Epping to Thornleigh Third Track Proposal. Application number SSI 5132.

Name(s): Christina C. Cook

I/we object to the Epping to Thornleigh Third Track Proposal and consider that the EIS is inadequate and does not address the full impact of this proposal. It will cause untold damage to the health of residents and to the fabric of the Beecroft Cheltenham Heritage Conservation Area. Do not approve this project, reconsider the alternatives and protect the community.

Figure S.6 Cross-section and elevation - New Cheltenham Station concourse building (see also S.5 for artist's impression)

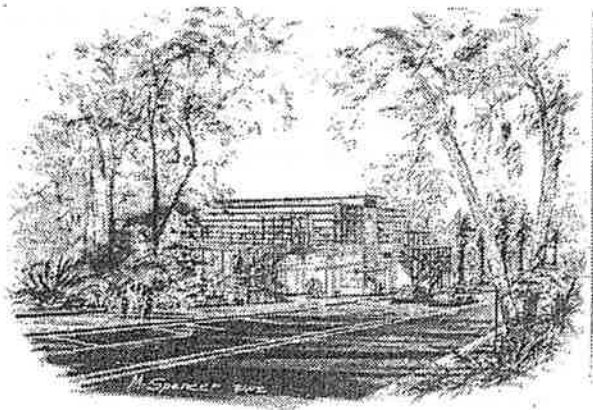
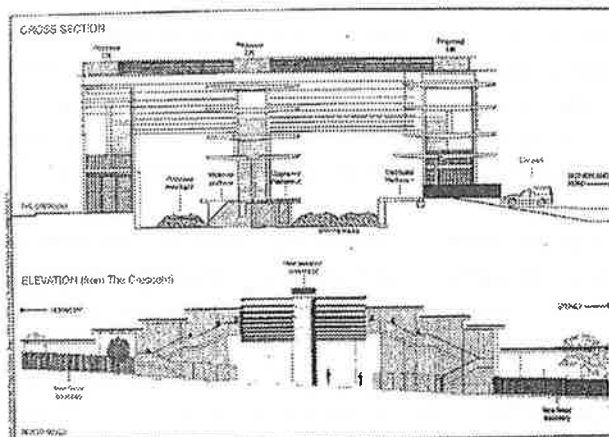
- The proposed redevelopment of Cheltenham Station shows no regard for the HCA. The visual impact of the proposed 13m high glass and steel concourse is totally unacceptable in this HCA.
